April 24, 2020  
Merrick Project No. 65120399

**Re: Mountain View Academy - Site Development Plan;  
Grading and Erosion Control Plan (PPR-20-008)**

Merrick & Company has reviewed the comments dated March 17, 2020 regarding the Mountain View Academy Site Development Plan and Grading and Erosion Control Plan. The following summarizes Merrick's responses to the comments provided by the El Paso County.

EXTENDED DETENTION BASIN OPERATION  
AND MAINTENANCE PLAN (PLAN AND PROFILE)

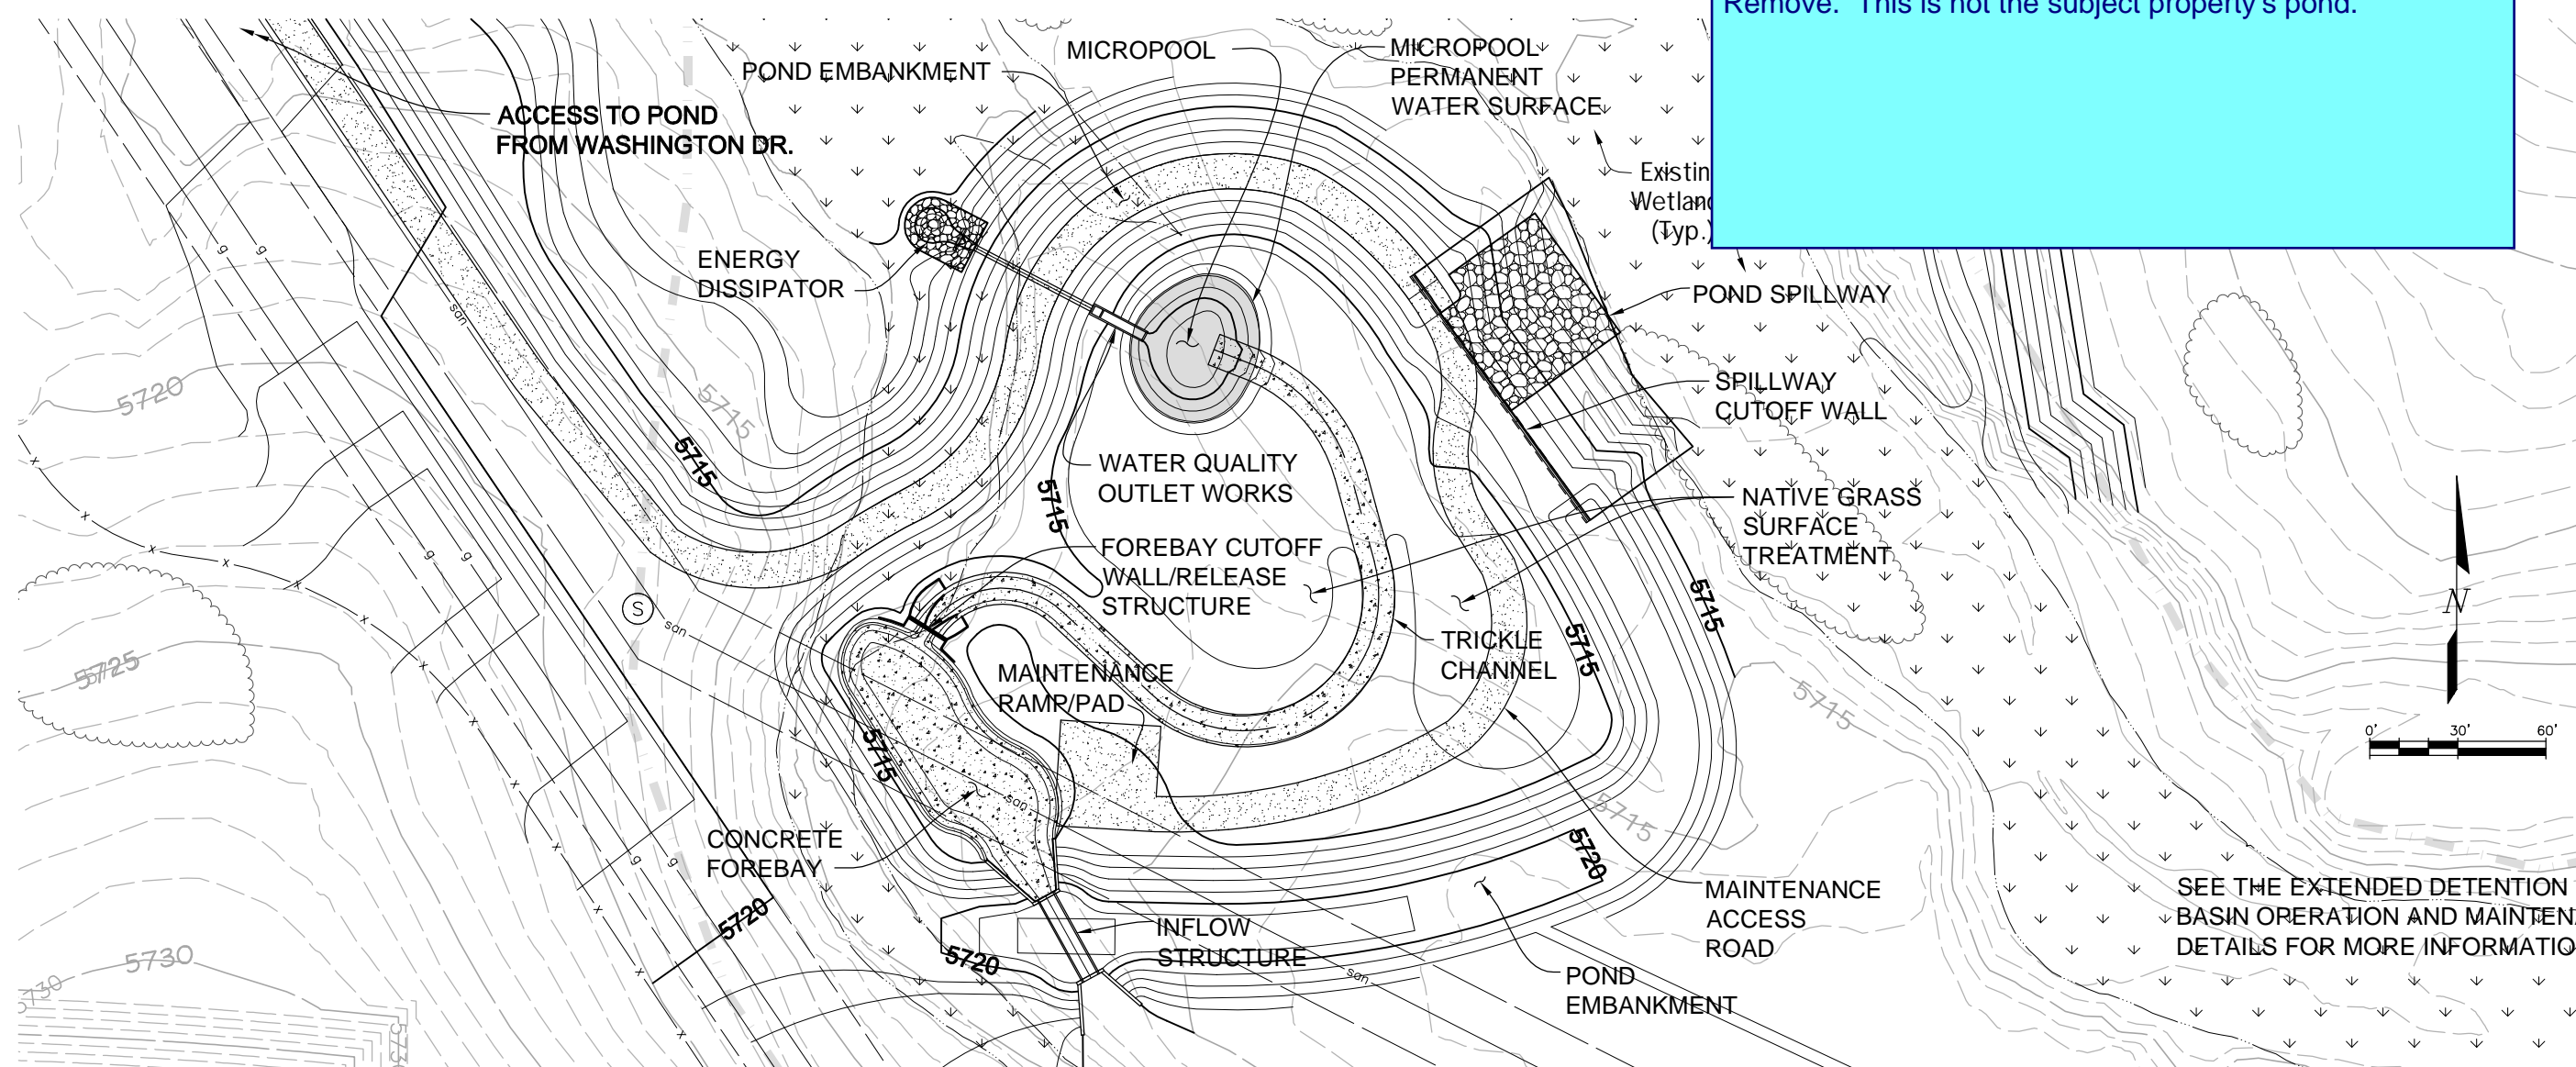
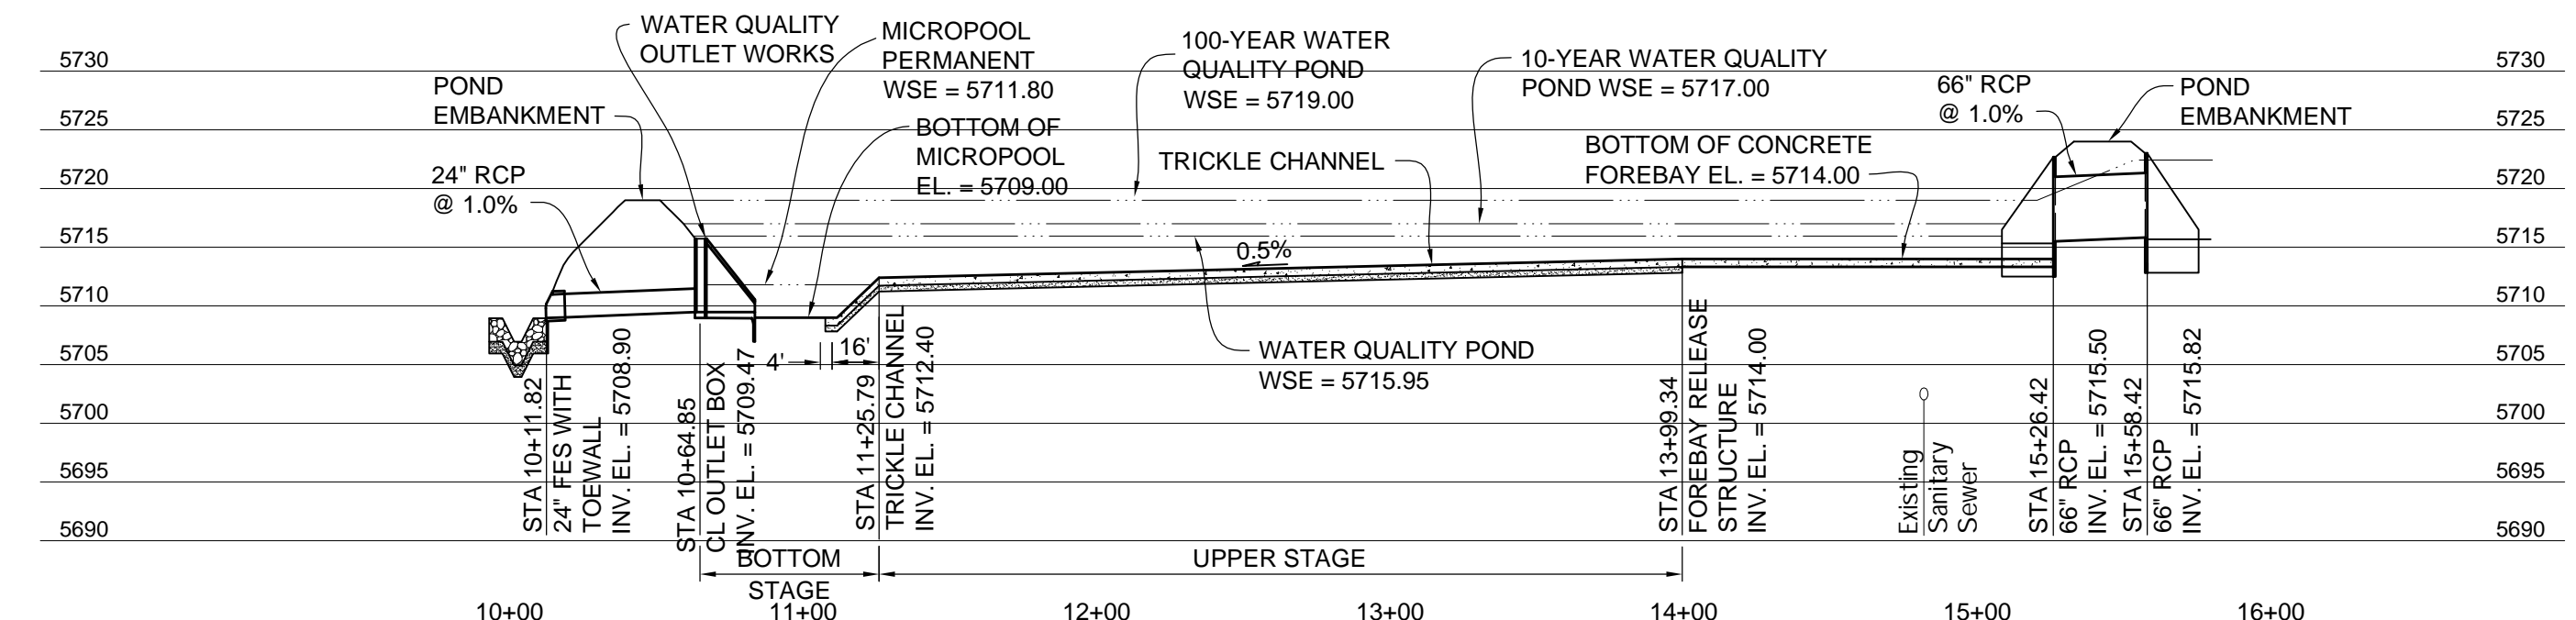
- Remove this sheet. (Extended Detention Basin)  
[Response: Removed](#)
- Remove this sheet. (O&M Site Plans EDB Checklist for Required Items – 2 pages)  
[Response: Removed](#)
- Remove. This is not the subject property's pond. (President's Ridge Phase 1 Plan – 2 Sheets)  
[Response: Removed](#)

SHEET: **C2.4**

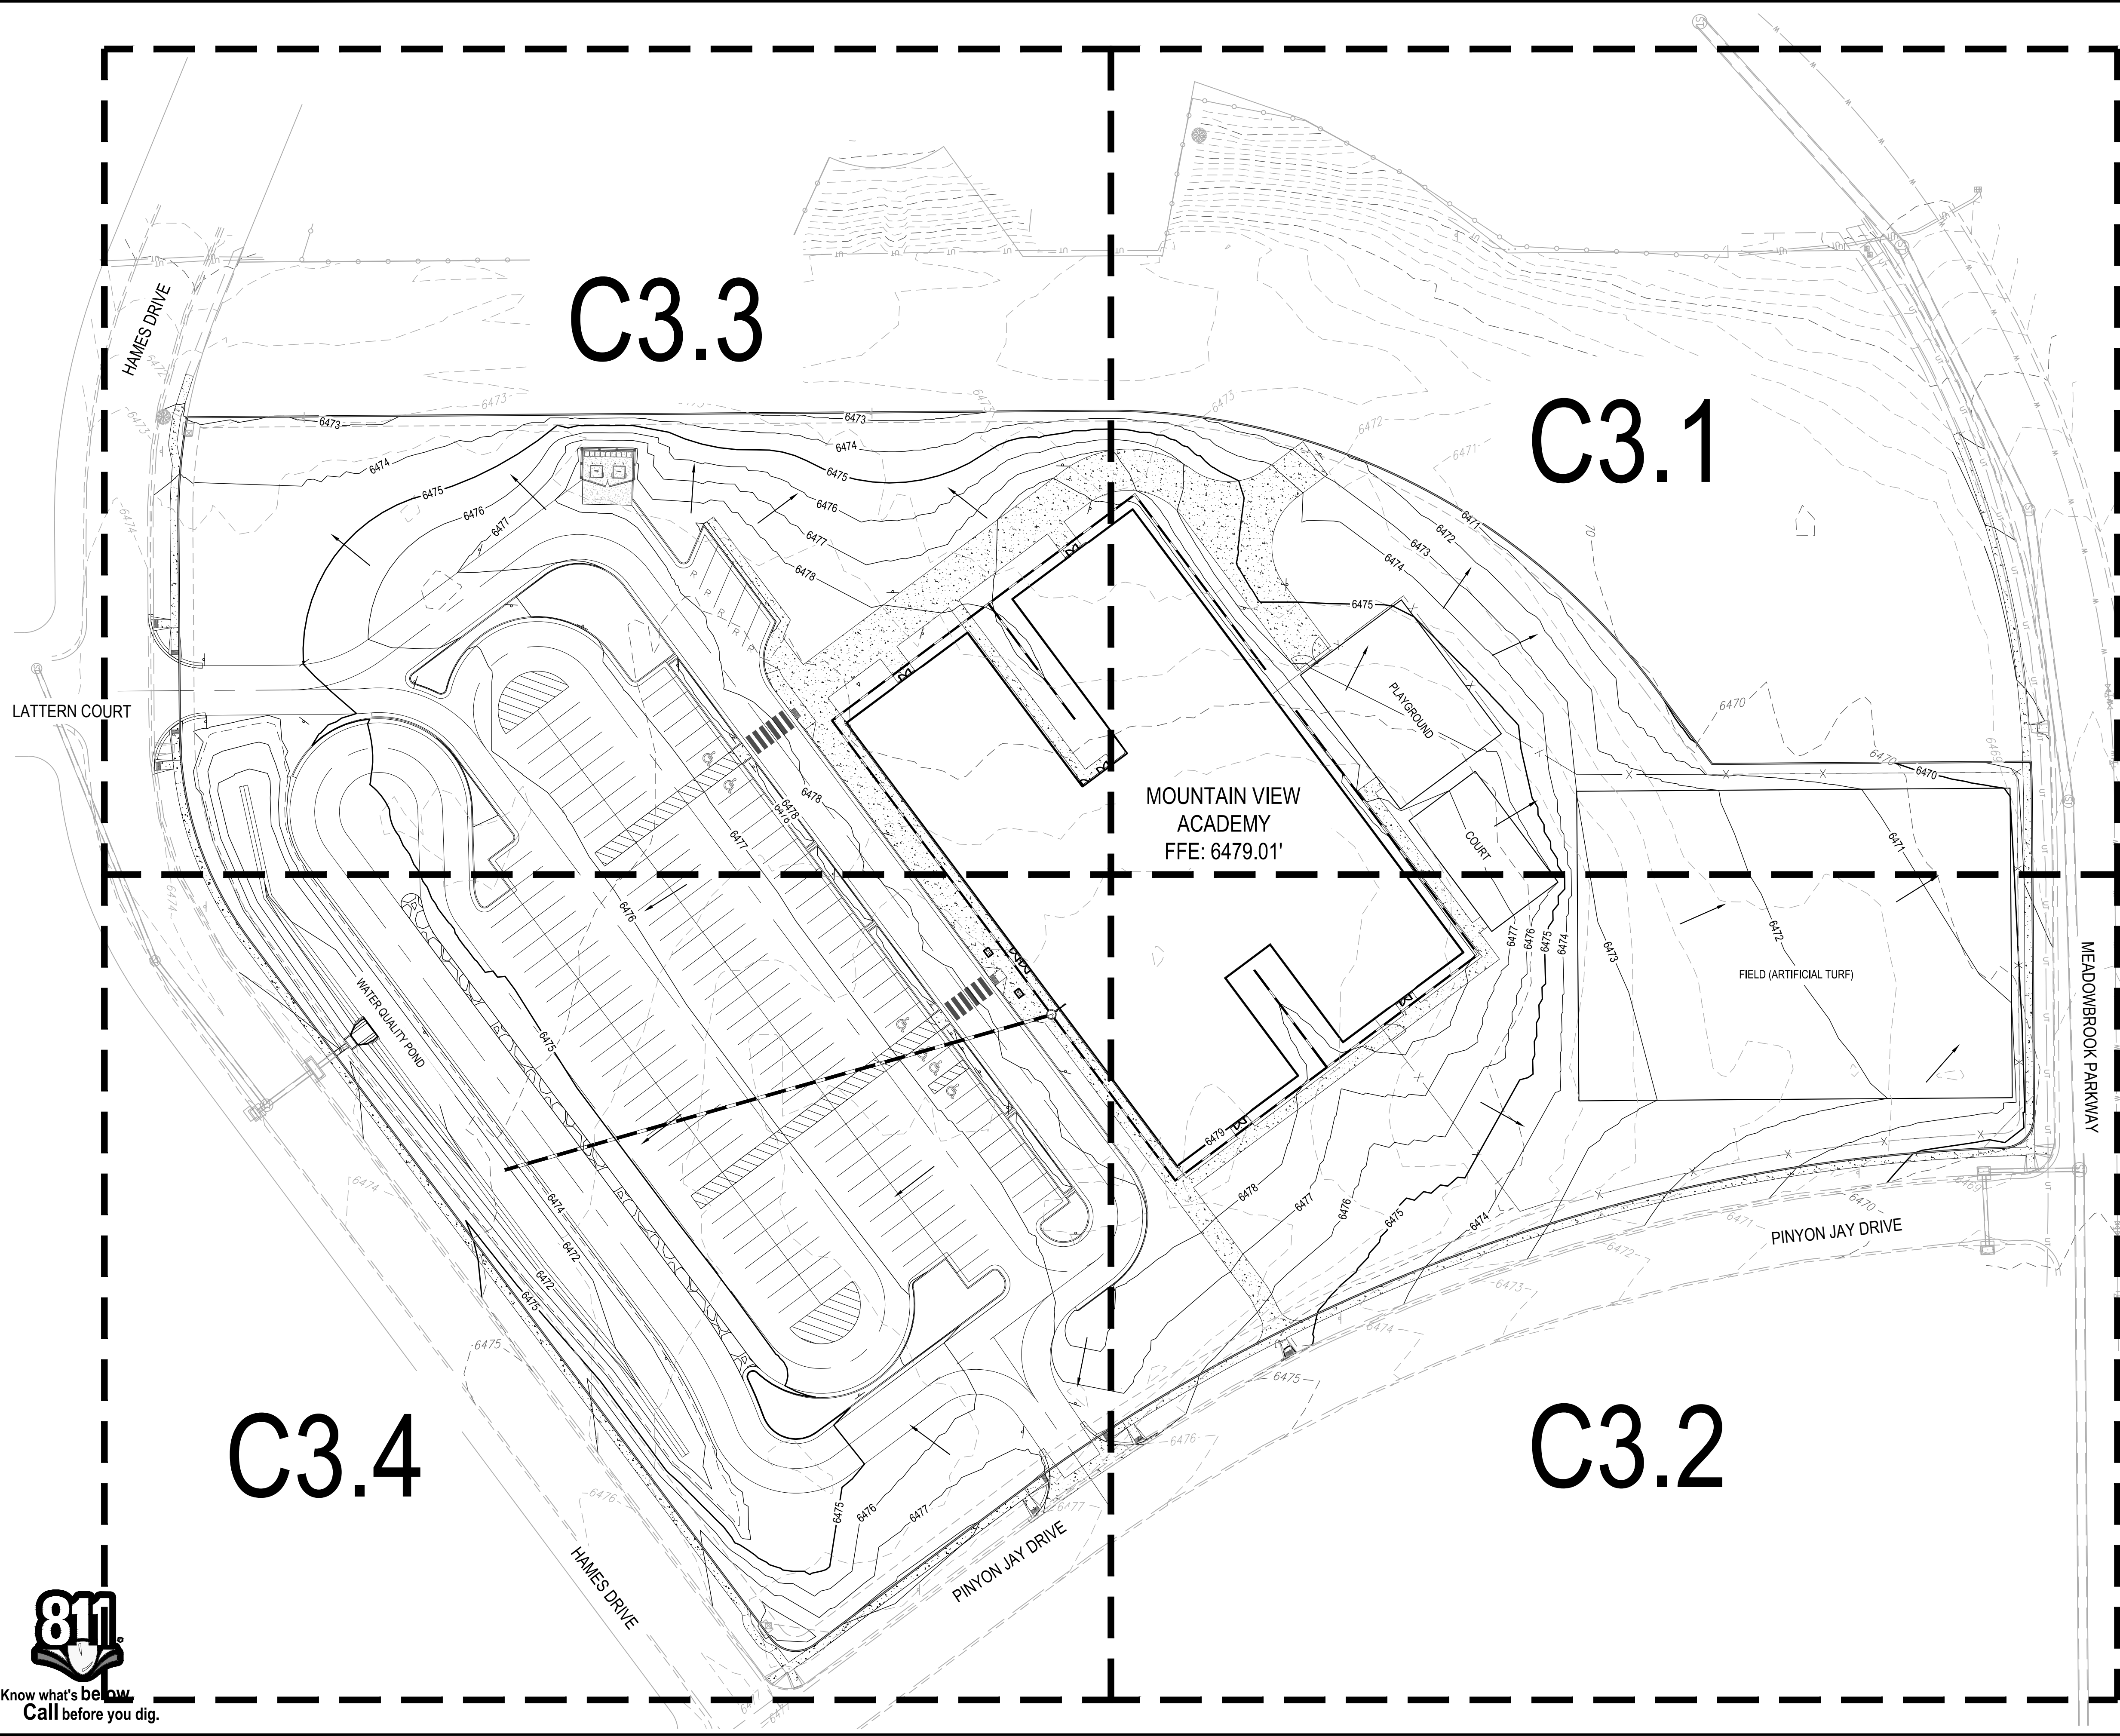
- Add utility trench repair detail SD\_4-20  
[Response: Detail added.](#)
